Lime Down Solar Park

**Planning Inspectorate Reference:
EN010168**

**Wiltshire Council Comments on Submissions
Received at Deadlines 1 and 1A**

Deadline 2 (22 May 2026)

Co-ordinate system: OSGB36 / British National Grid
Scale: 1:8000 @ A3

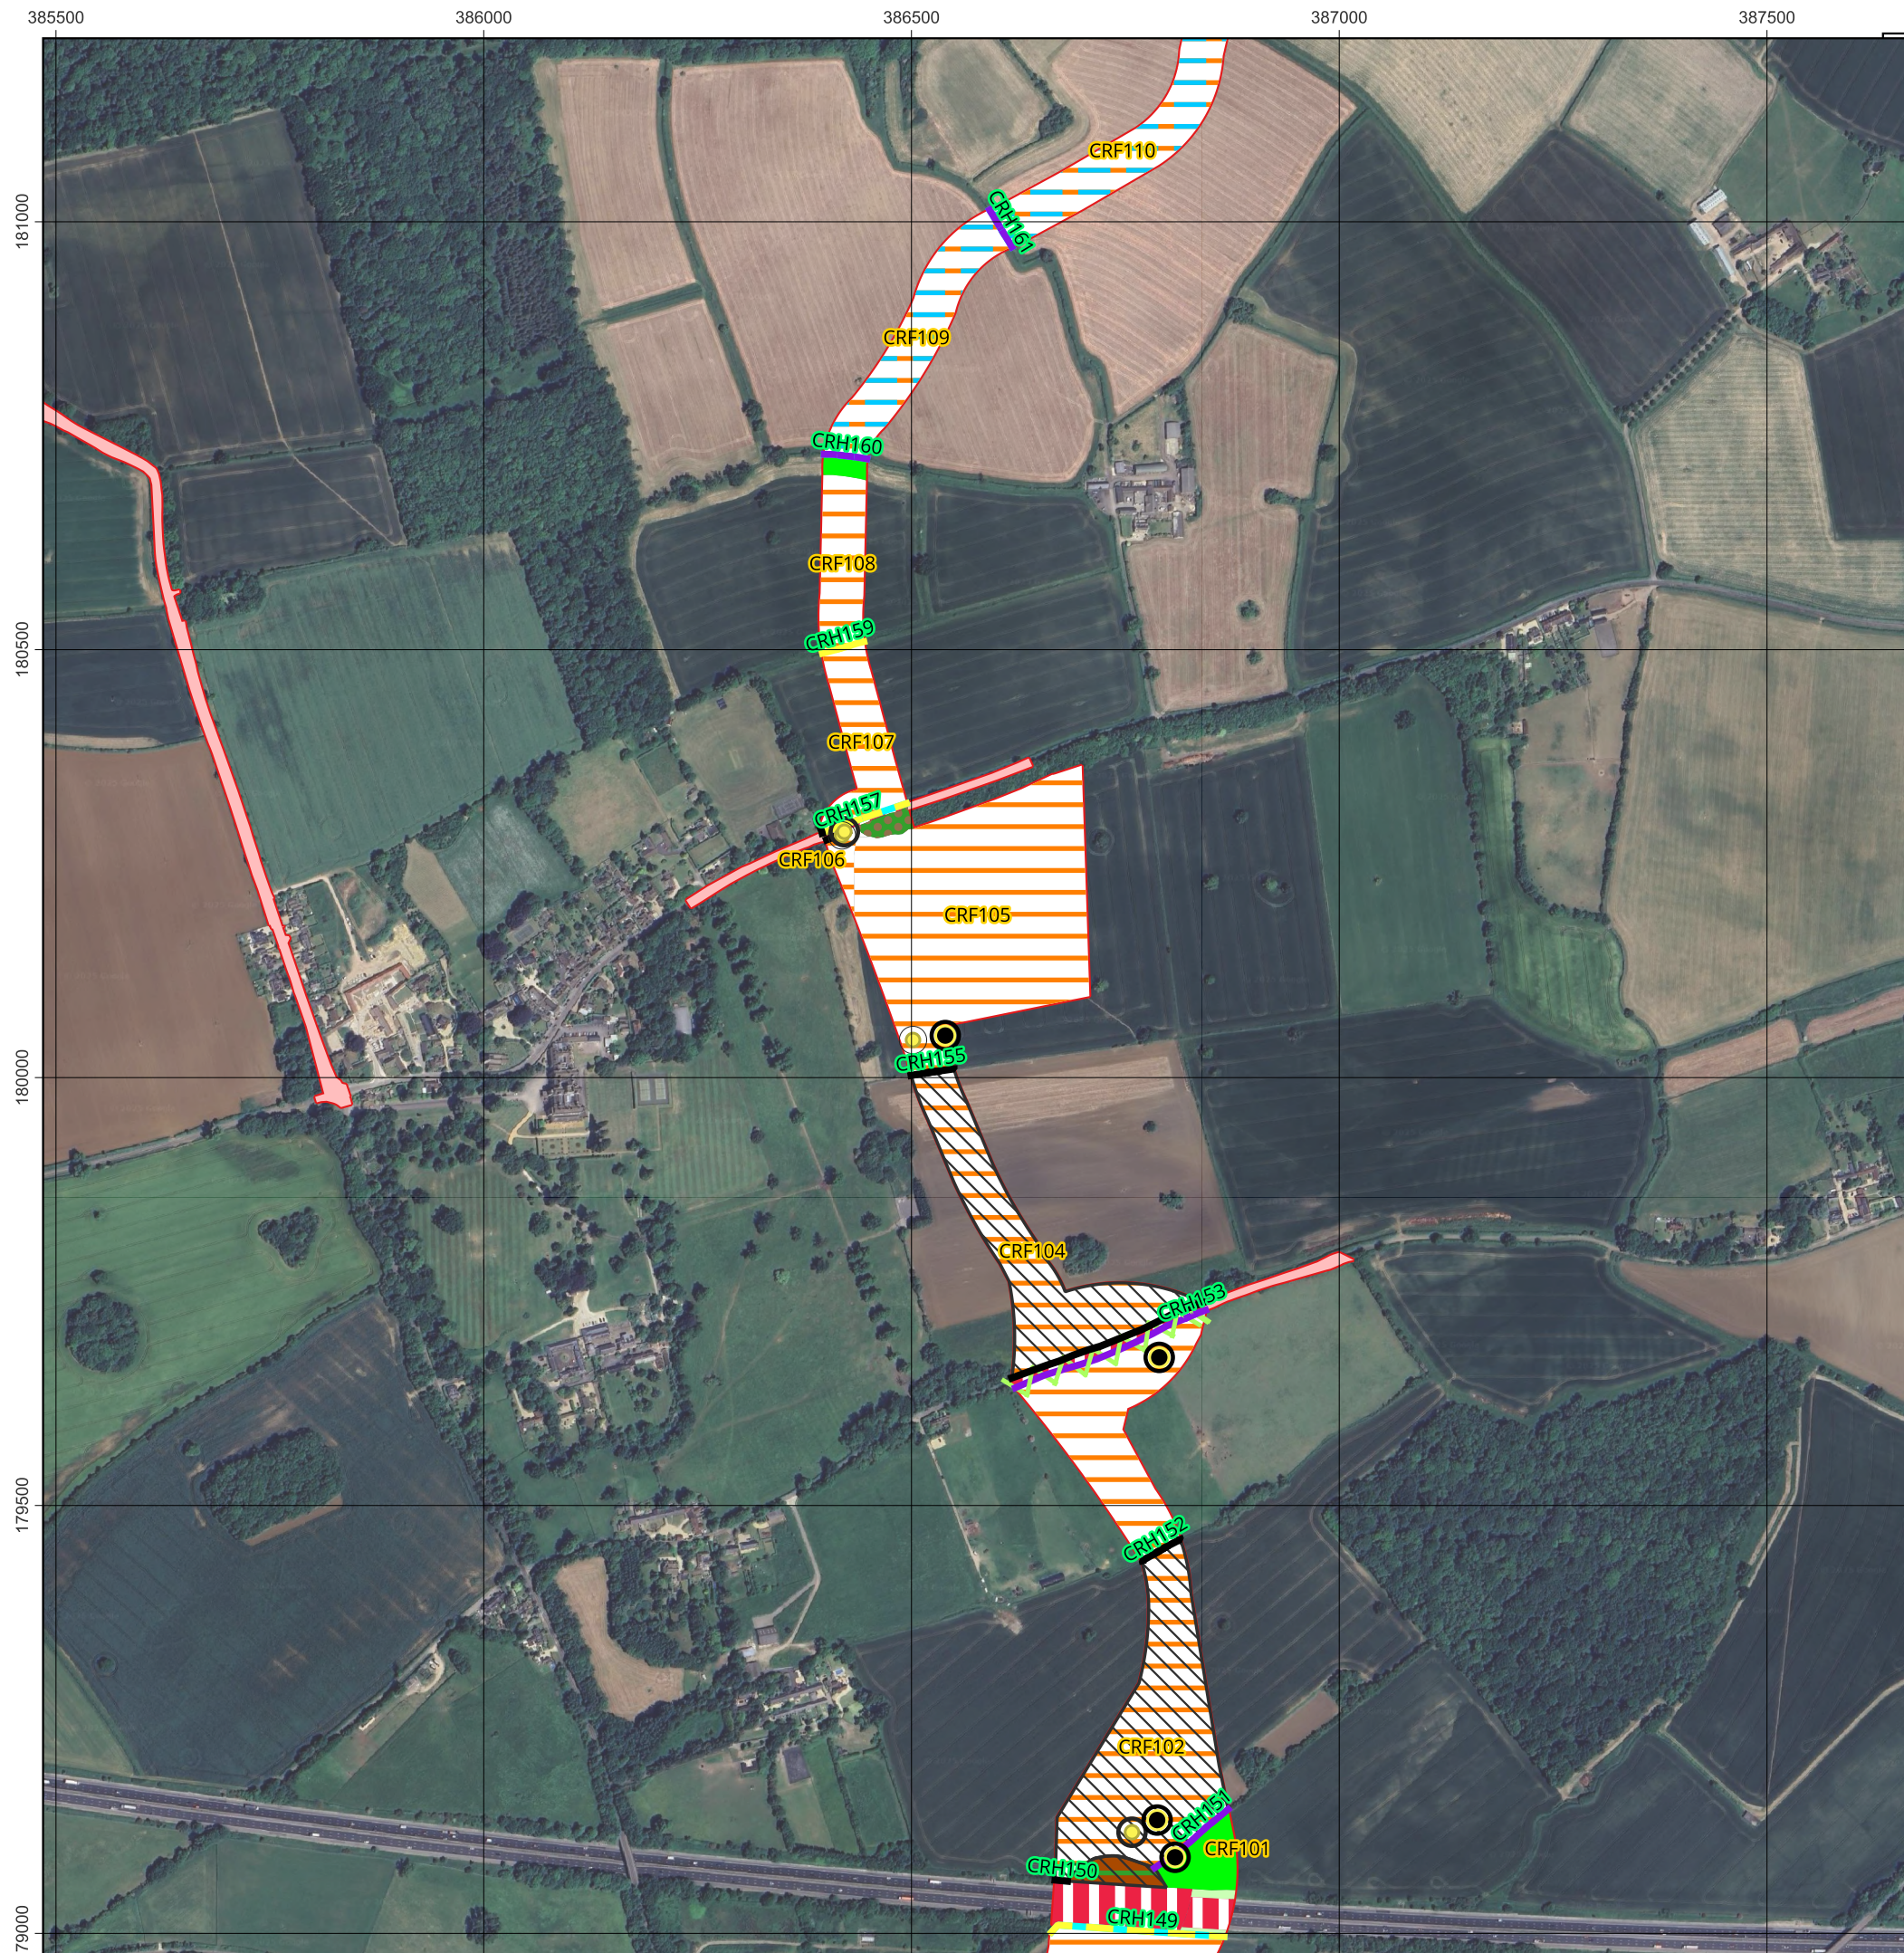
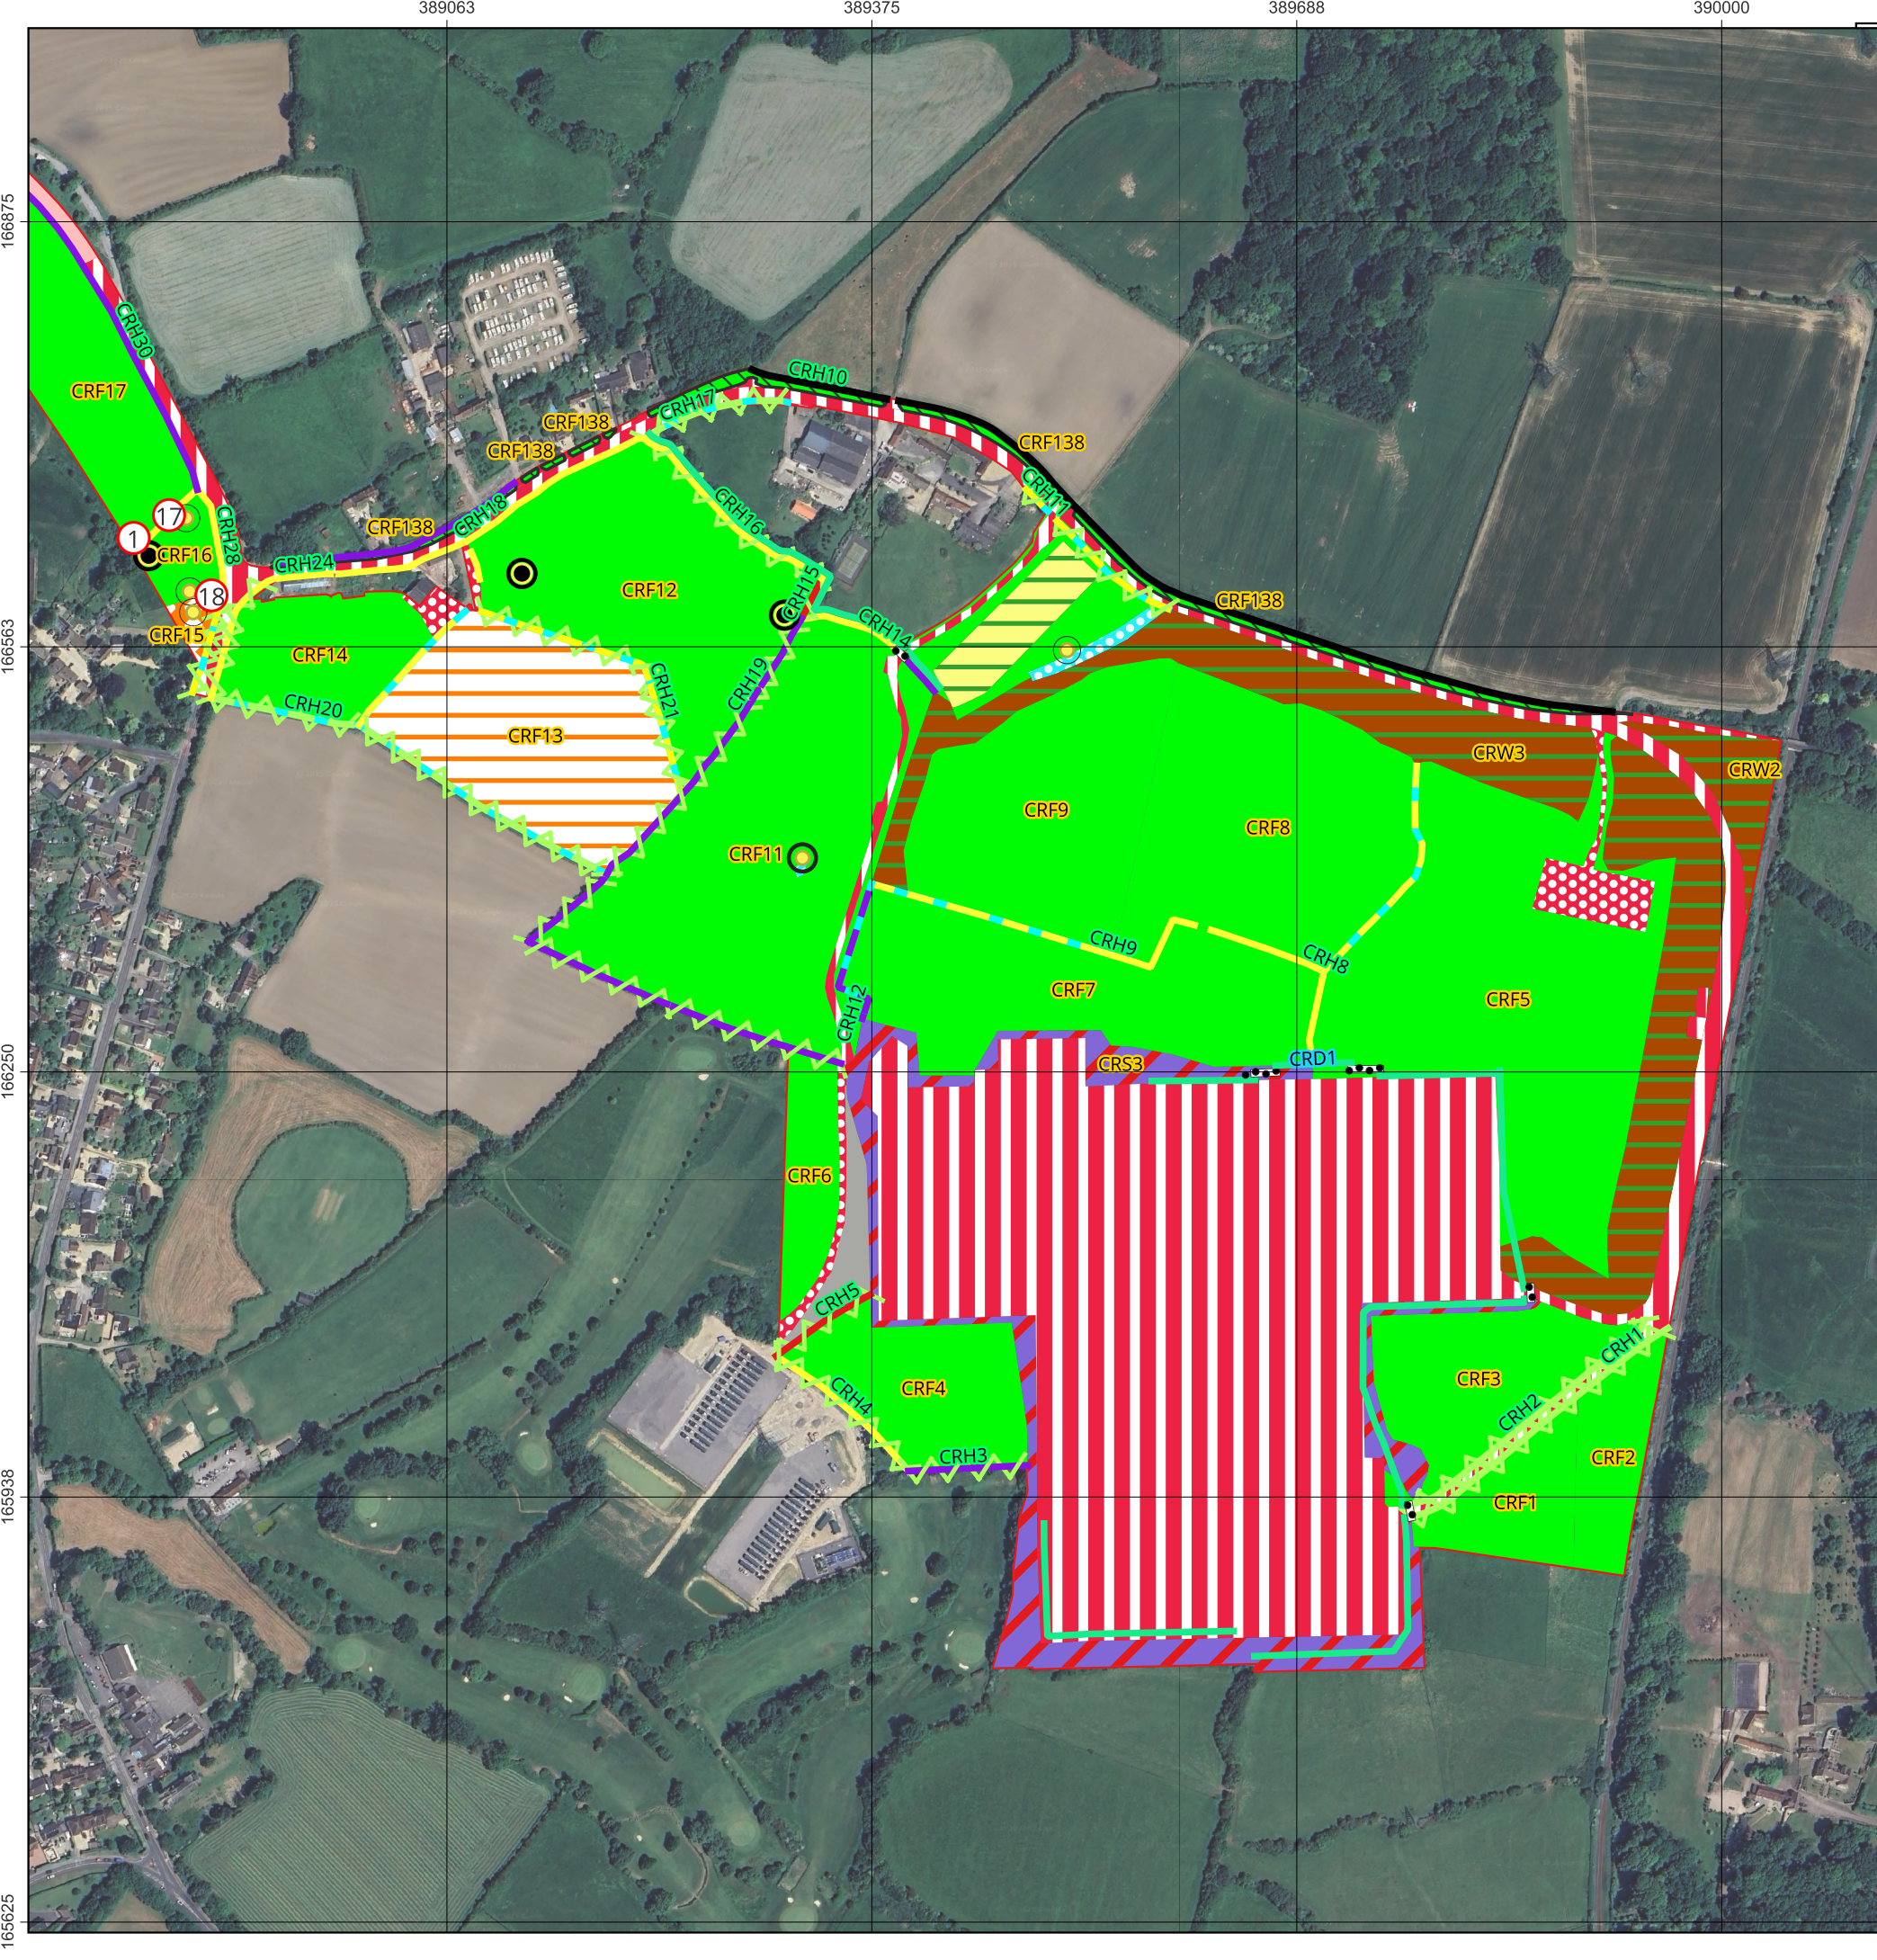
- 5.1. In respect of other neutral grassland (ONG), it is noted that revisions to **Table 9-8** and **Paragraph 9.10.100** indicate a reduction in the estimated area of ONG present within the cable route corridor from 15.44 ha as detailed in the last iteration of ES Chapter 9, to 3.06 ha in the Rev 2 iteration submitted at Deadline 1.
